**Mrs A Gardner
5 The Plantation
East Preston**

Your Ref :
Our Ref : EP/123/18/NMA

Section 96A of the Town & Country Planning Act 1990 (as amended)
Town and Country Planning (Development Management Procedure) (England) Order 2015 (as amended) - Article 10
Application for a non-material amendment following a grant of planning permission EP/26/18/HH relating to loft conversion with two dormers, plus a replacement conservatory roof.
5 The Plantation, East Preston, ,

Job Title	5 THE PLANTATION, EAST PRESTON			Item	PROPOSED EAST & WEST ELEVATIONS	
Designed by	Date	Checked by	Job No.	Sheet	FR. 05	Rev. A

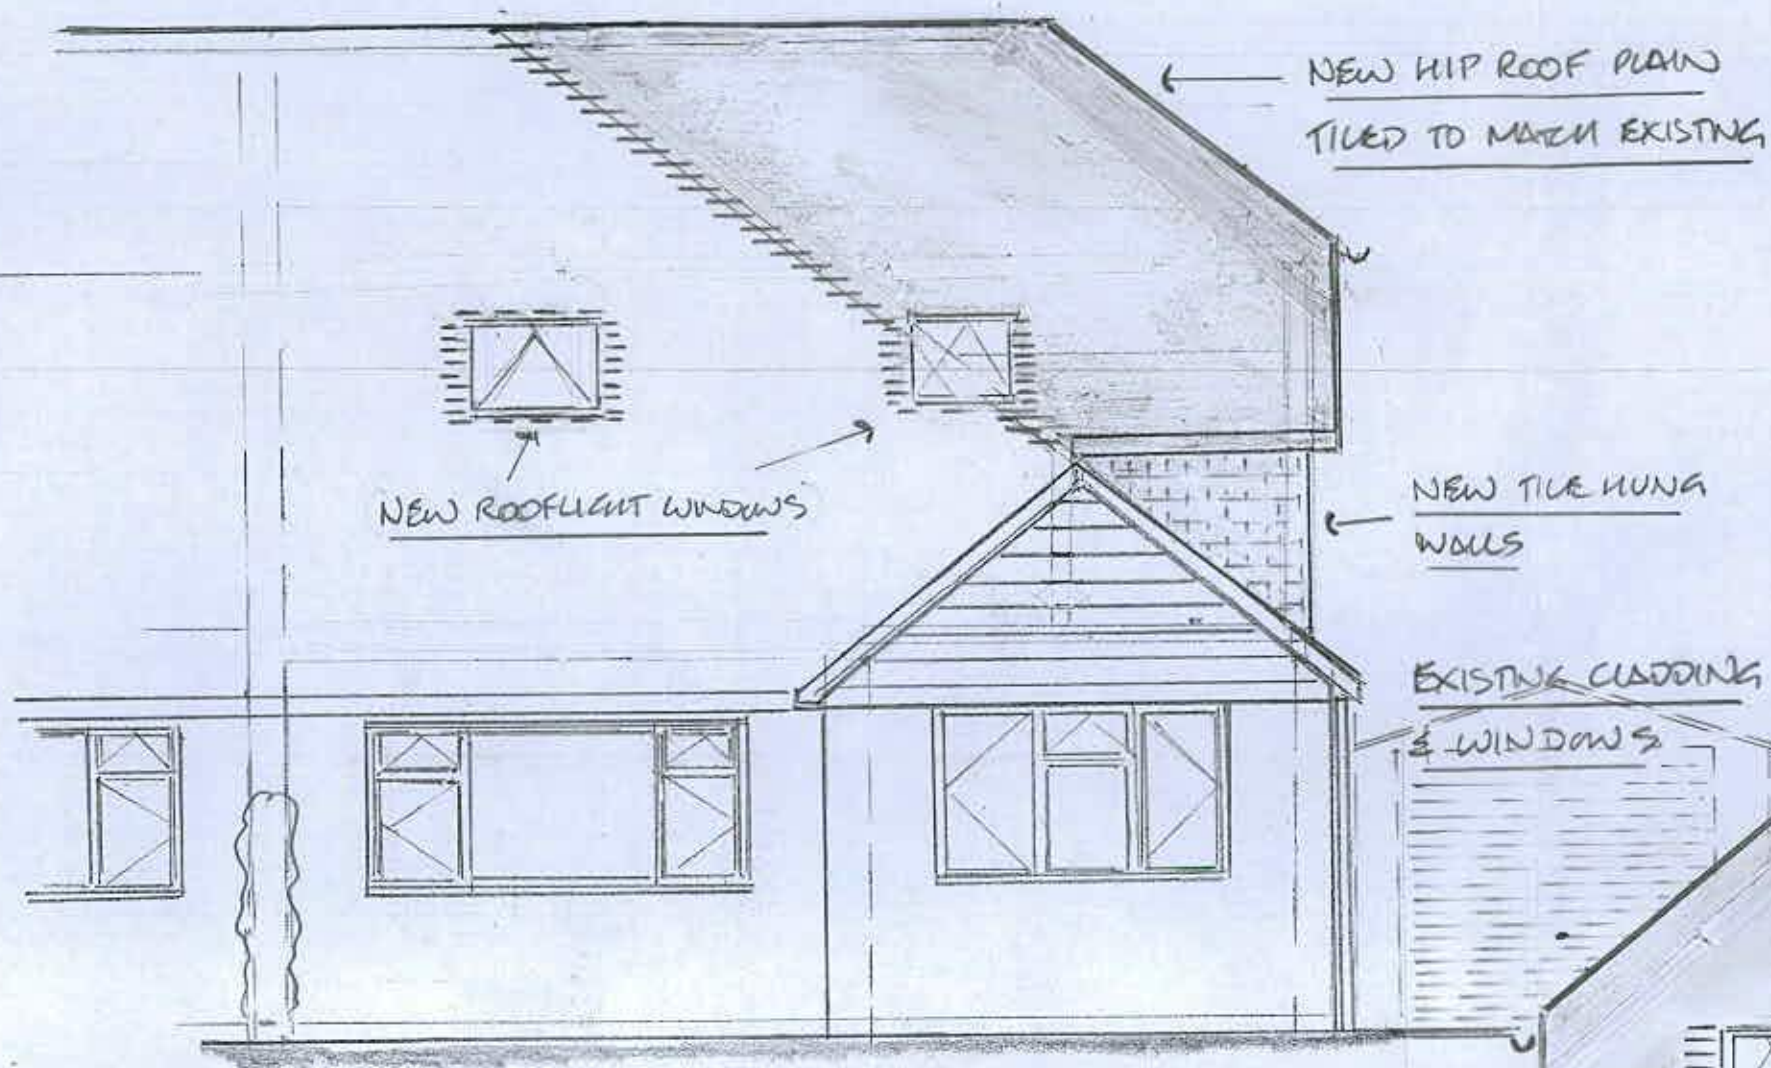
I refer to your recent application for a Non Material Minor Amendment. I note that you proposed to change one of the proposed plans (Proposed East and West Elevations - FP05) as to correct a drafting error, which incorrectly showed the length of the main roof. This amendment is described in the application form submitted on the 10/08/2018.

The proposed details are accepted as a Non-material amendment and now become the approved details for EP/26/18/HH. The approved plans are hereby:

- Proposed East and West Elevations - FP05 - Rev. A
